Our Ref: LU/250/19/HH

**Town & Country Planning Act 1990 (as amended)
Town & Country Planning (Development Management Procedure) (England) Order 2015
Application for Planning Permission for Works or Extension to a Dwelling**

Development Single storey rear extension and two storey side extension

Location 40 Parkside Avenue Littlehampton

PROPOSED SIDE (SOUTH)
ELEVATION

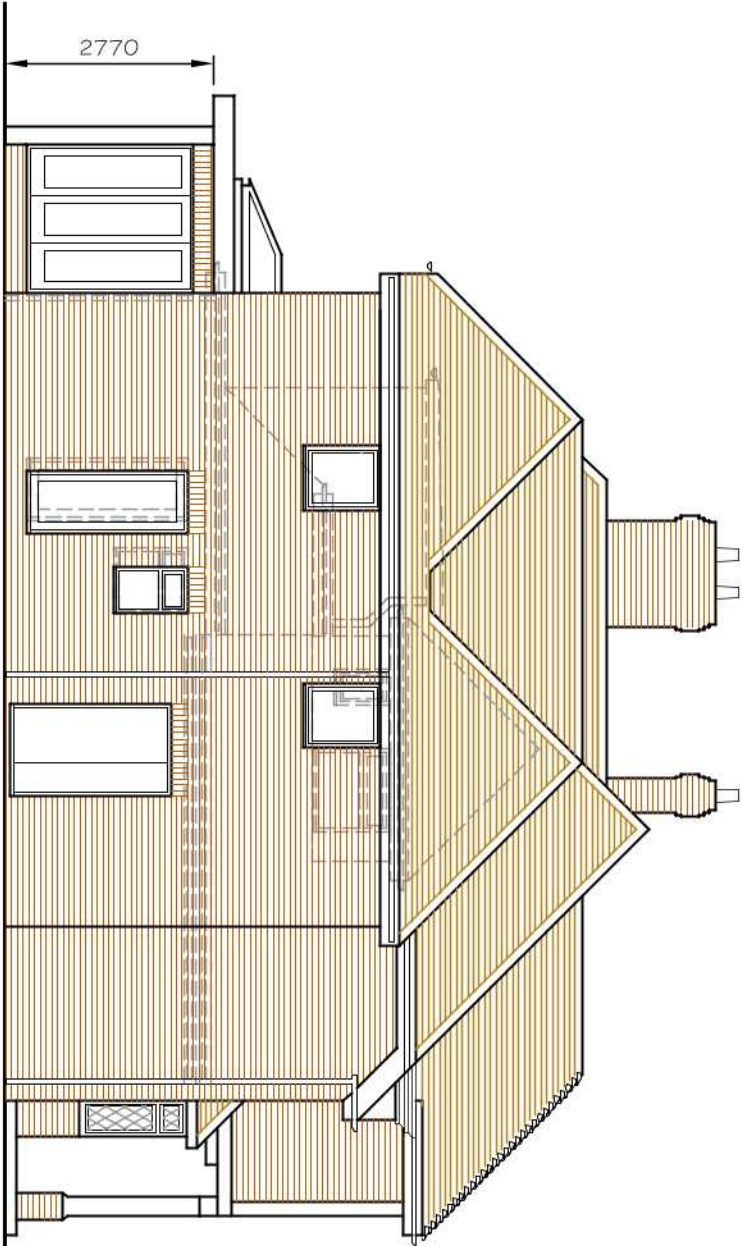
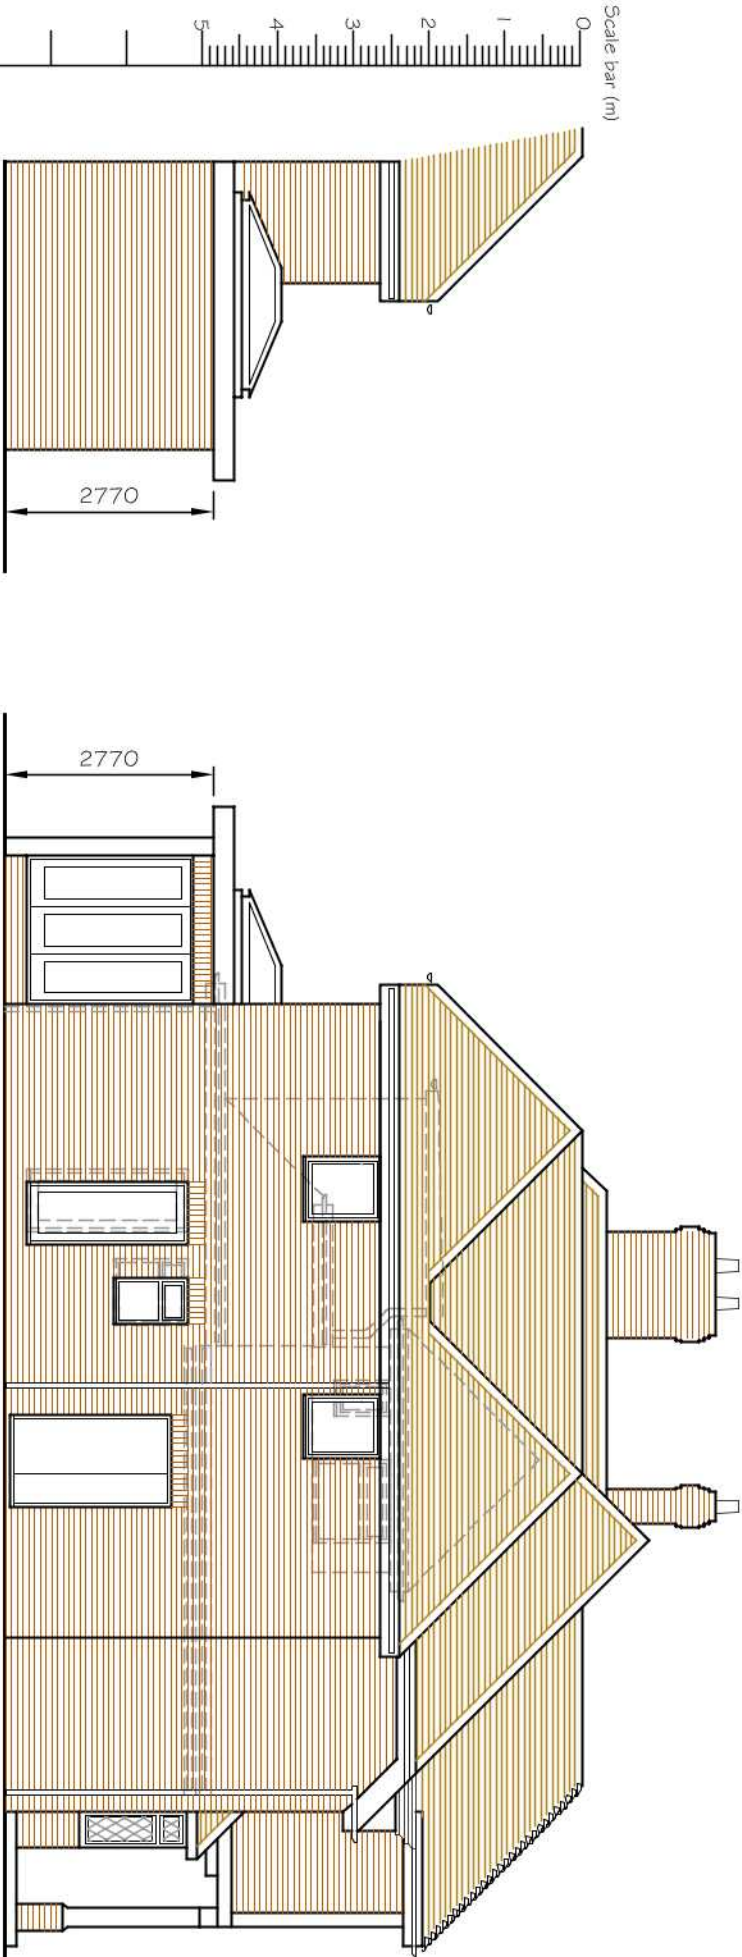
Side Elevation: Please provide the other side elevation as the extension extends beyond the neighbours property line.

BLOCK PLAN 1 : 500

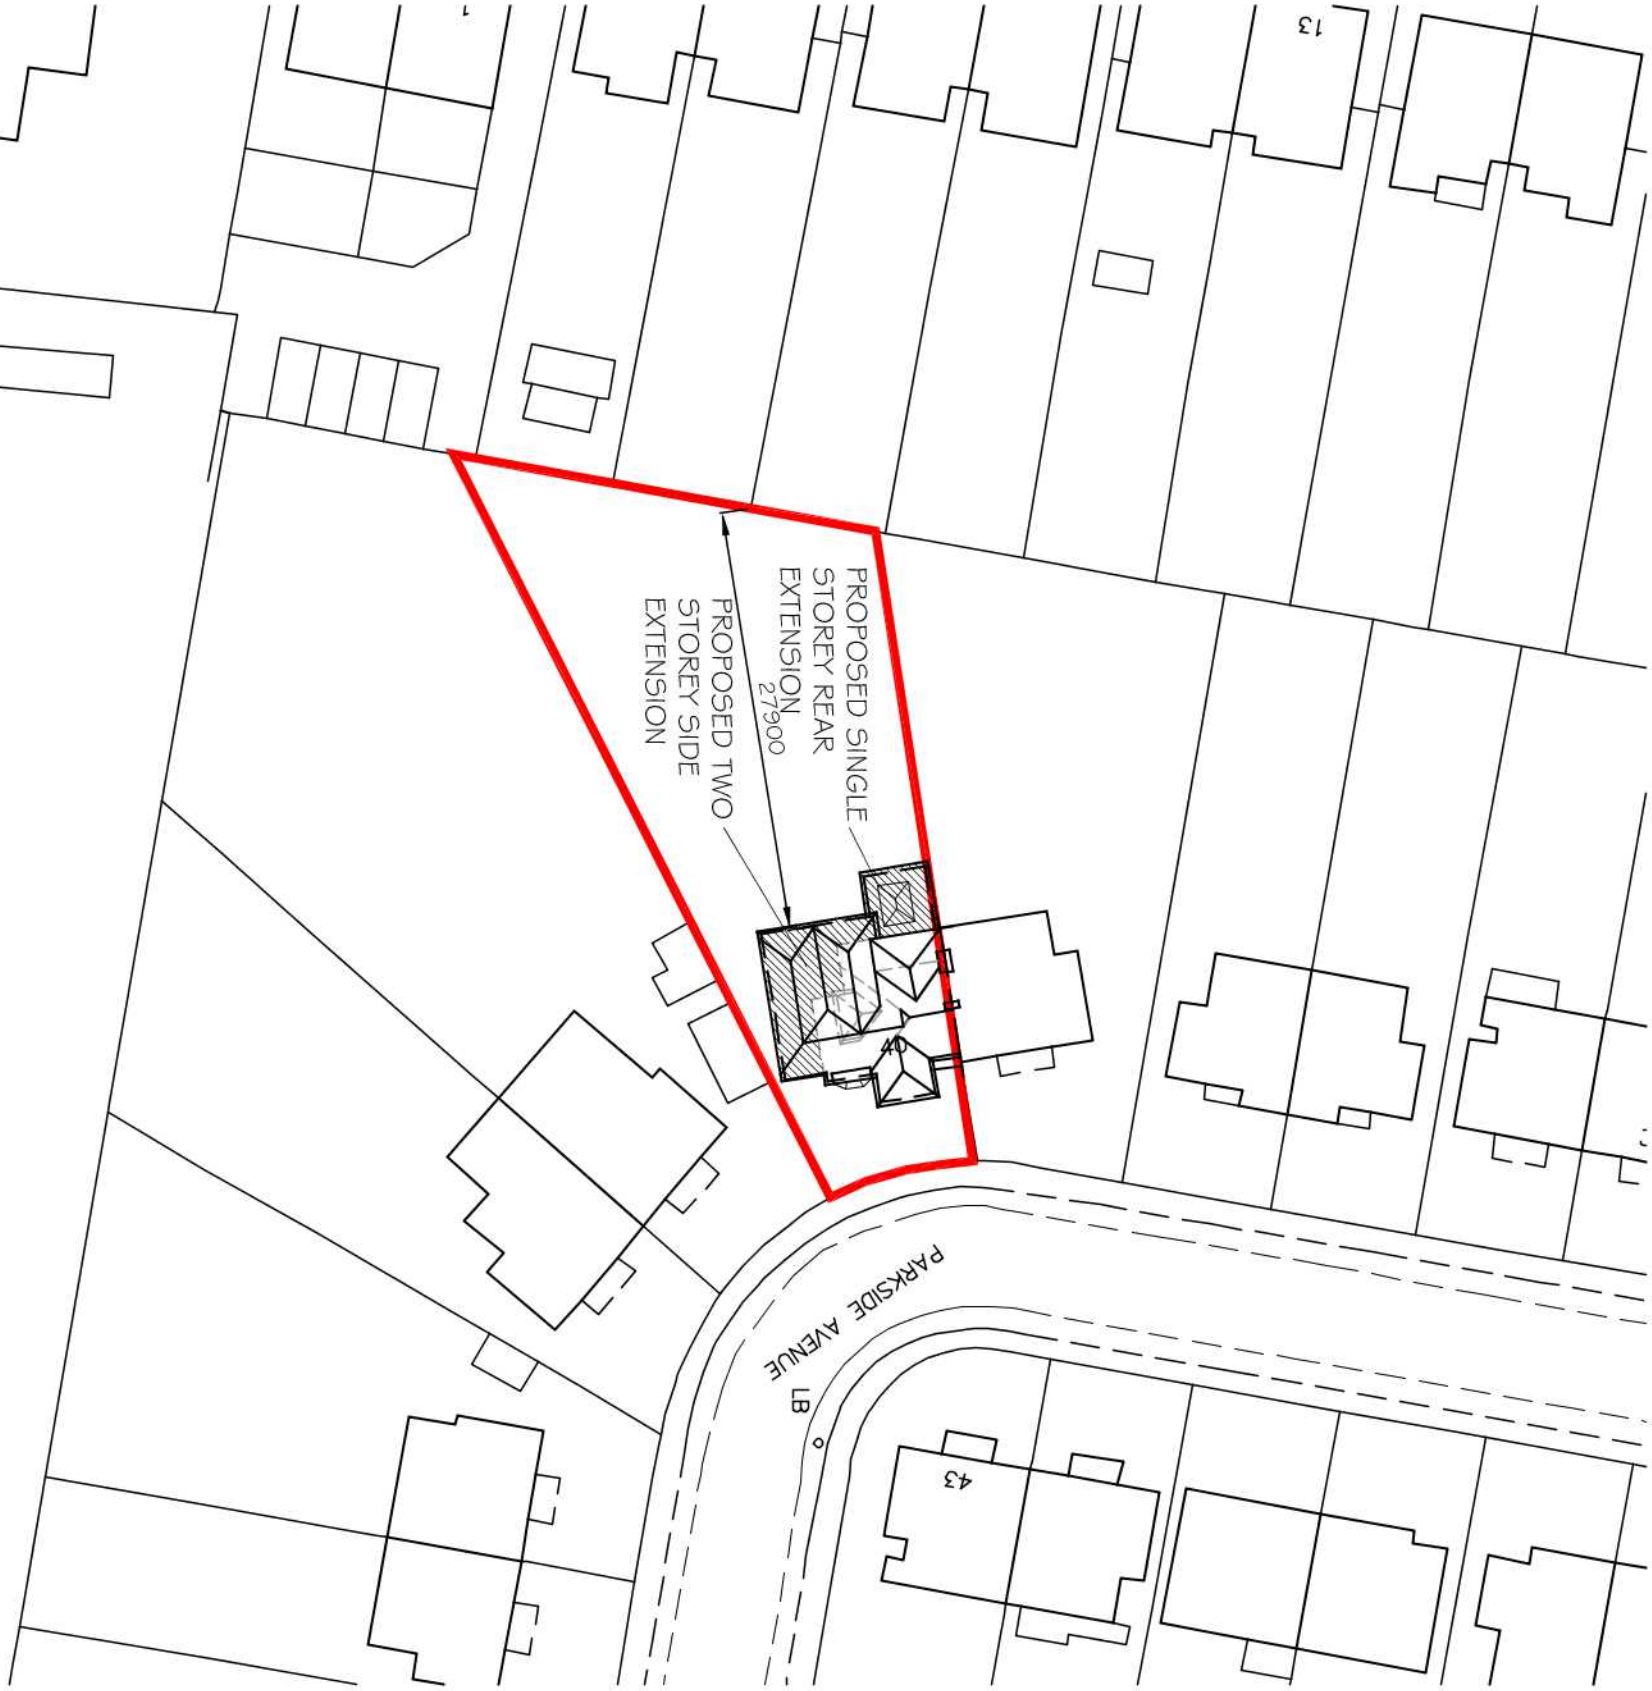
Block Plan

You are required to include dimensions from the proposed extensions to all site boundaries on the block plan. Please amend.
